**EPC STORMWATER REVIEW COMMENTS  
IN ORANGE BOXES WITH BLACK TEXT**

**SMALL SUBDIVISION FINAL DRAINAGE REPORT  
FOR  
CLOVERLEAF FILING NO. 1**

**December 1, 2020**

**Add text:  
PCD Filing No.: SF-21-014**

EXISTING DRAINAGE MAP

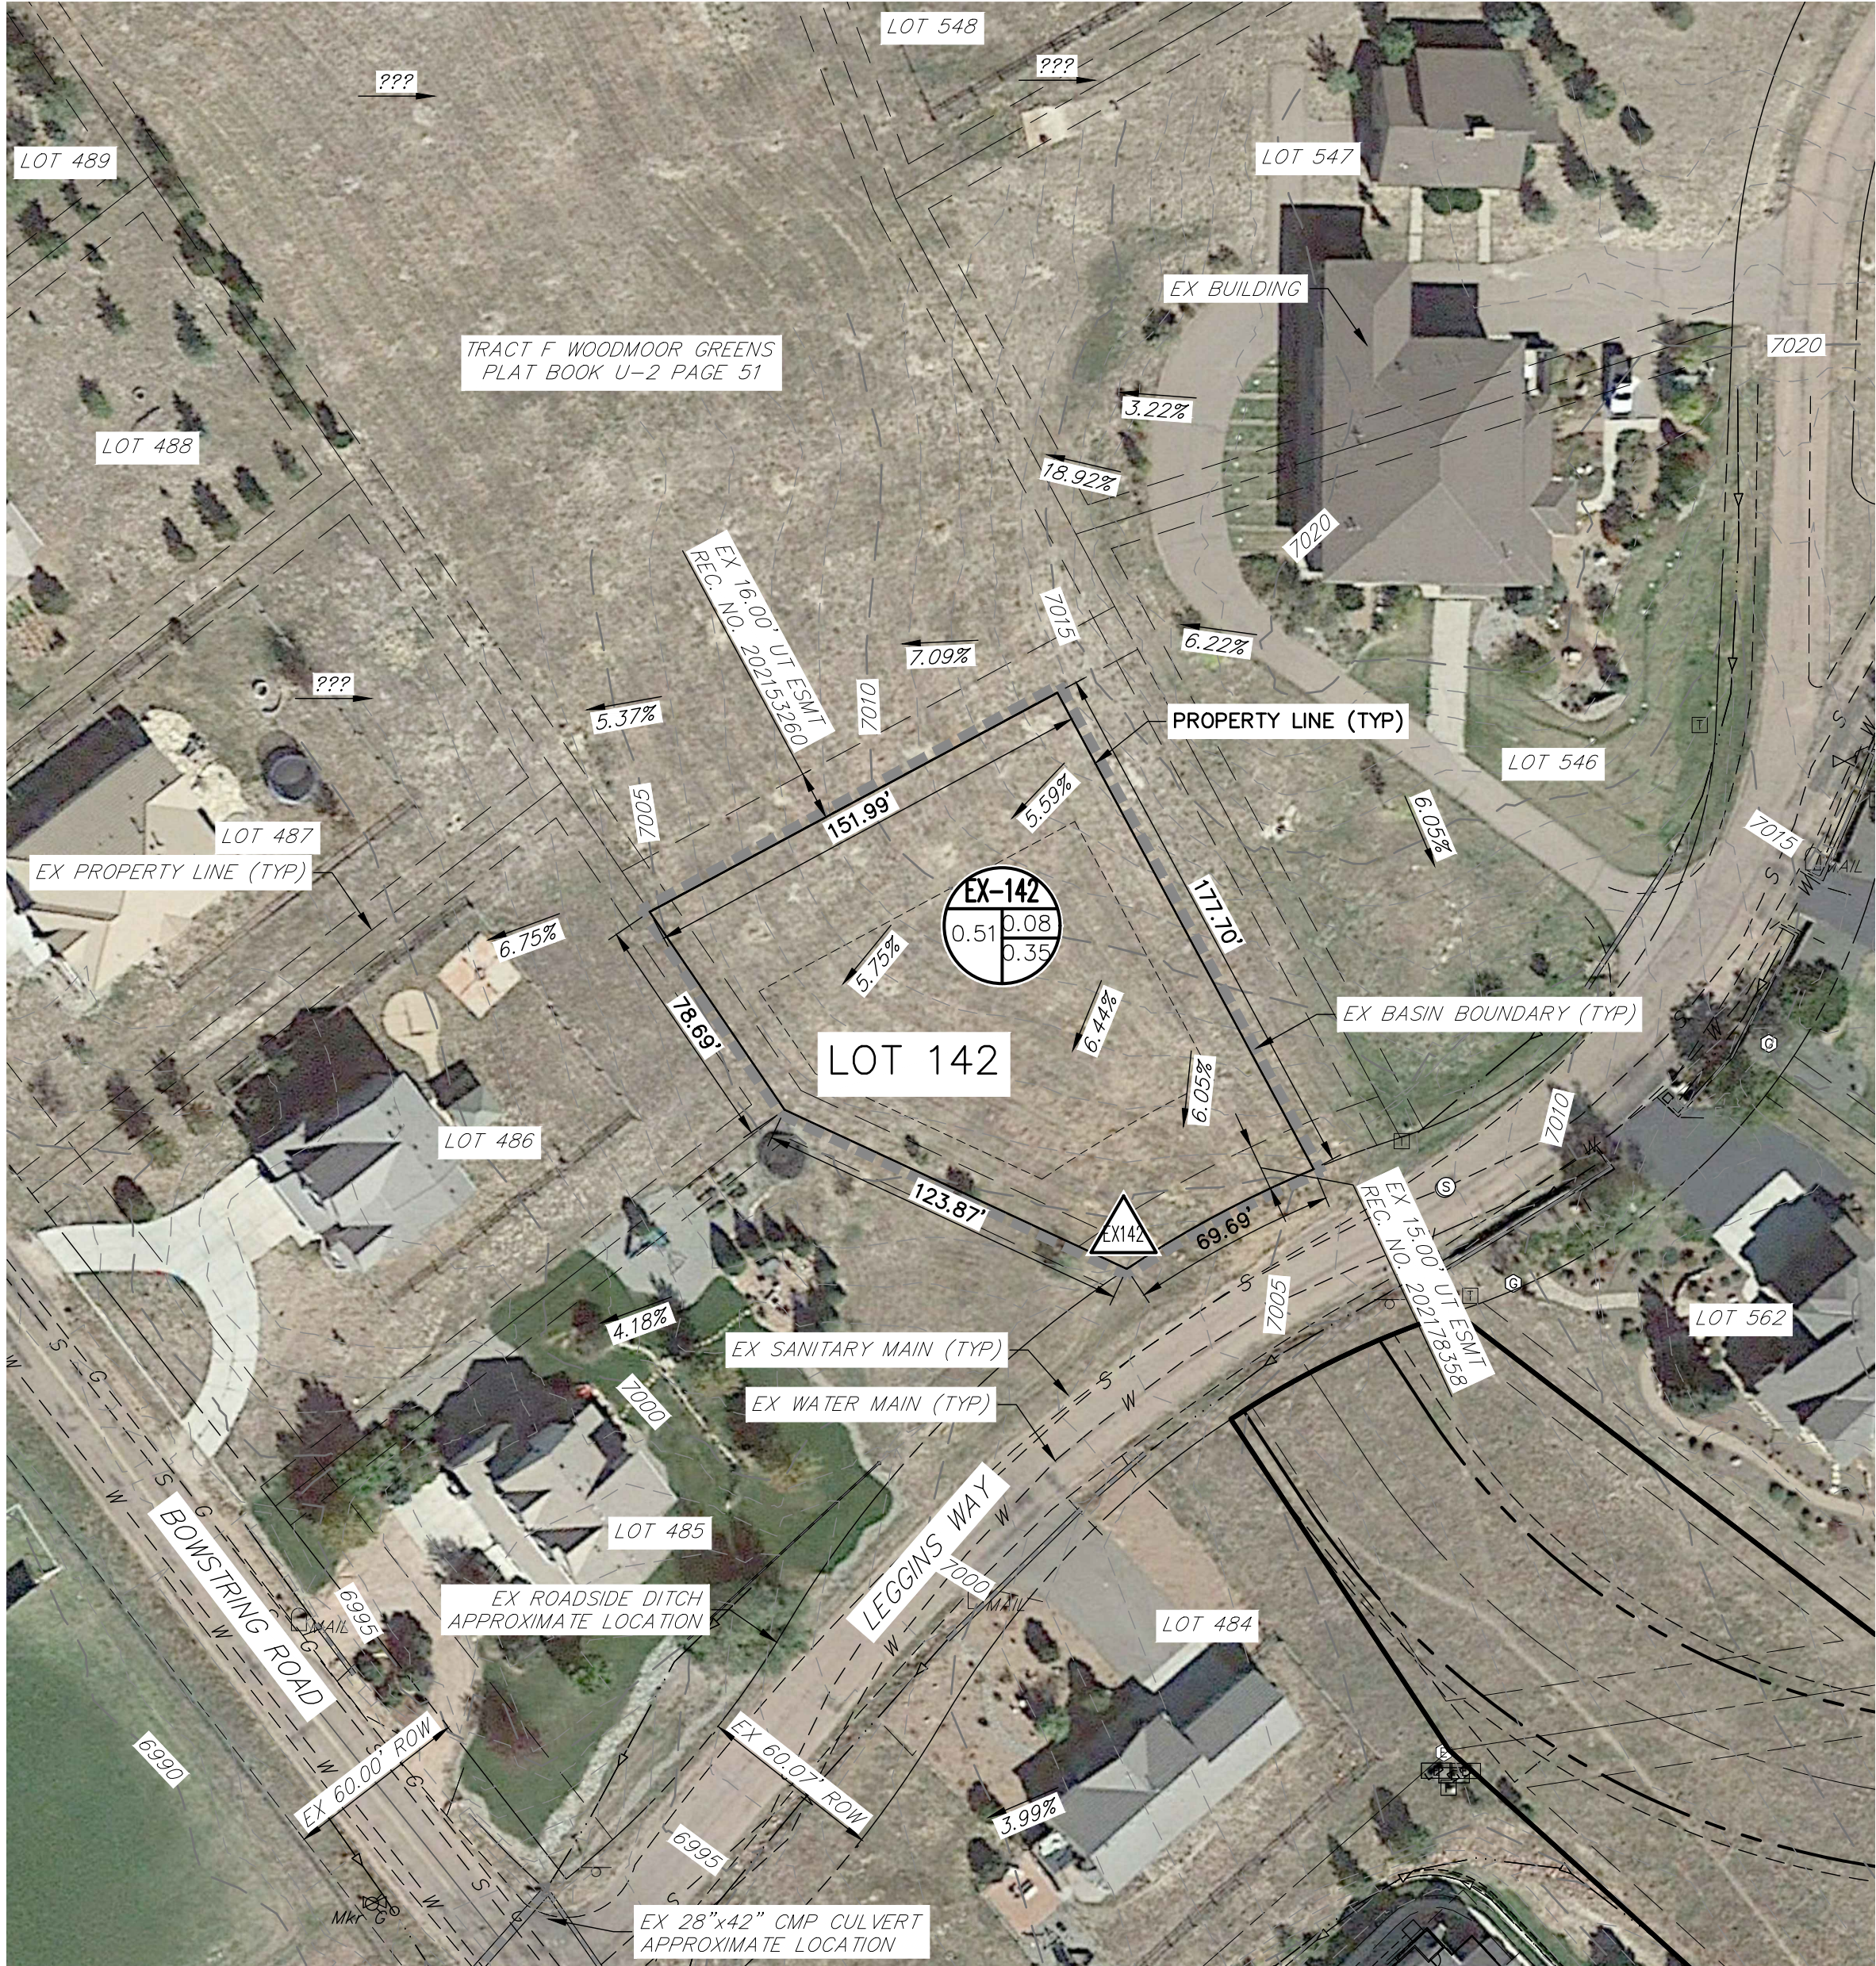
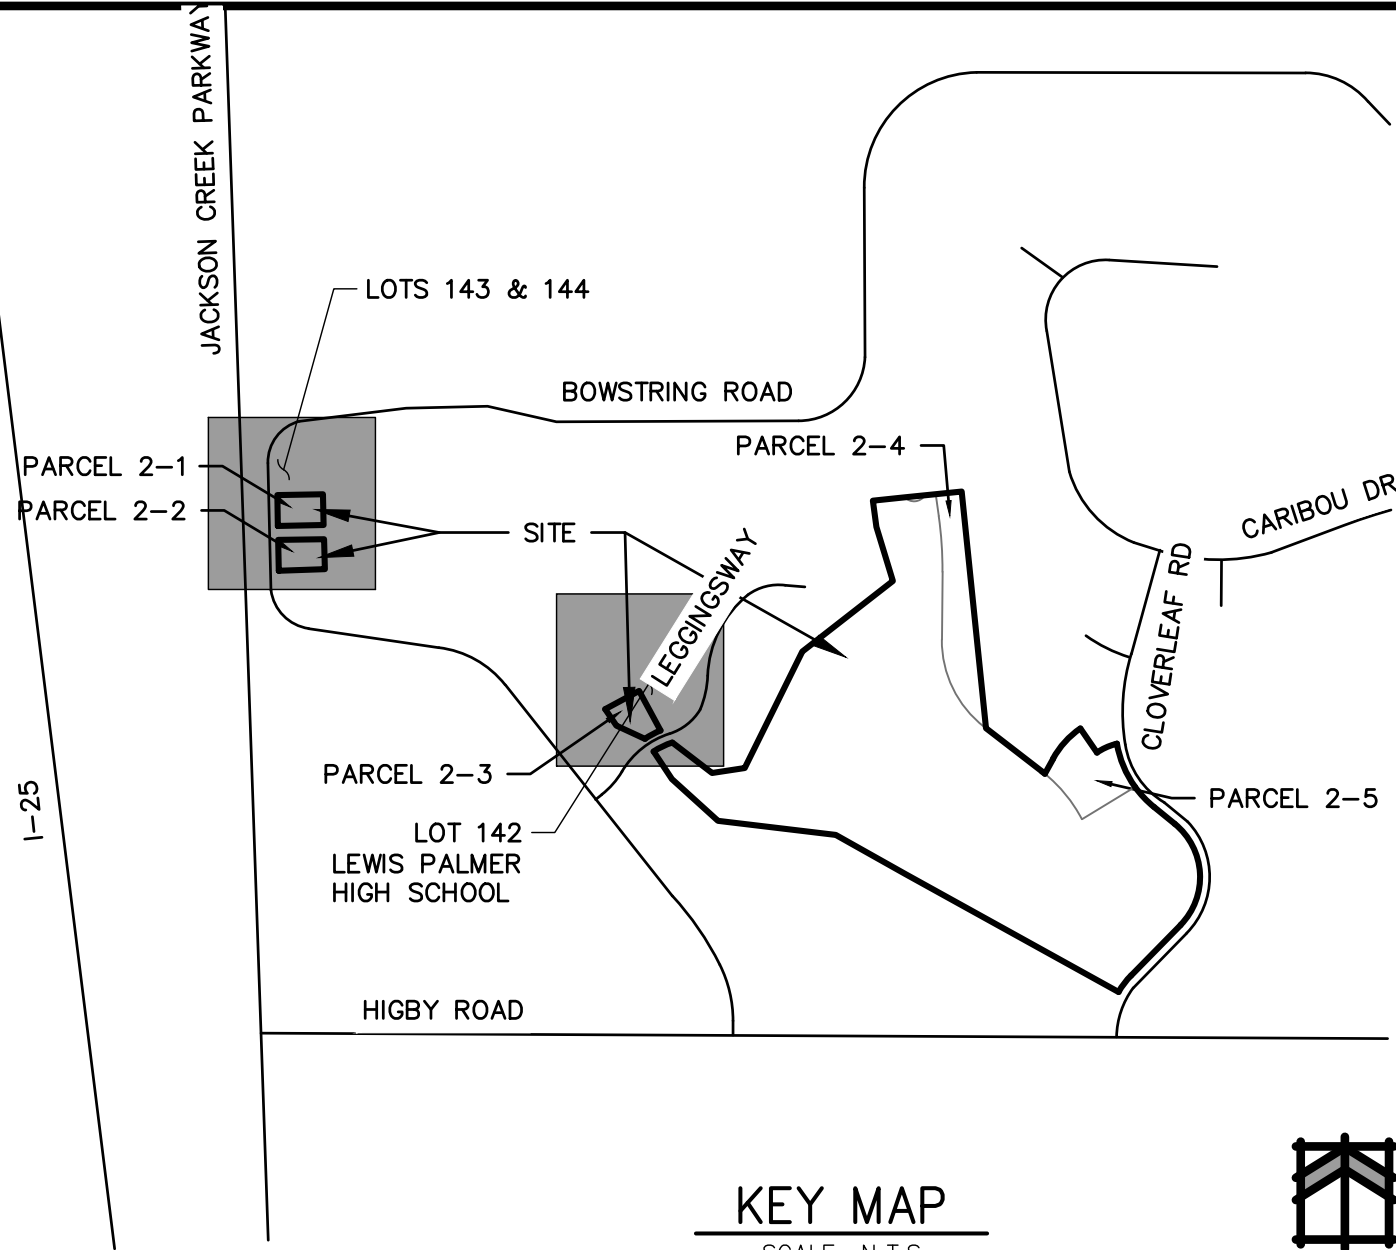
Please explain how. Is there a berm around the property to prevent offsite flow from entering the site? It looks like the land to the east of lots 143 and 144 flows onto these lots.  
If needed, include tributary basins into the rational method calcs in Appendix B
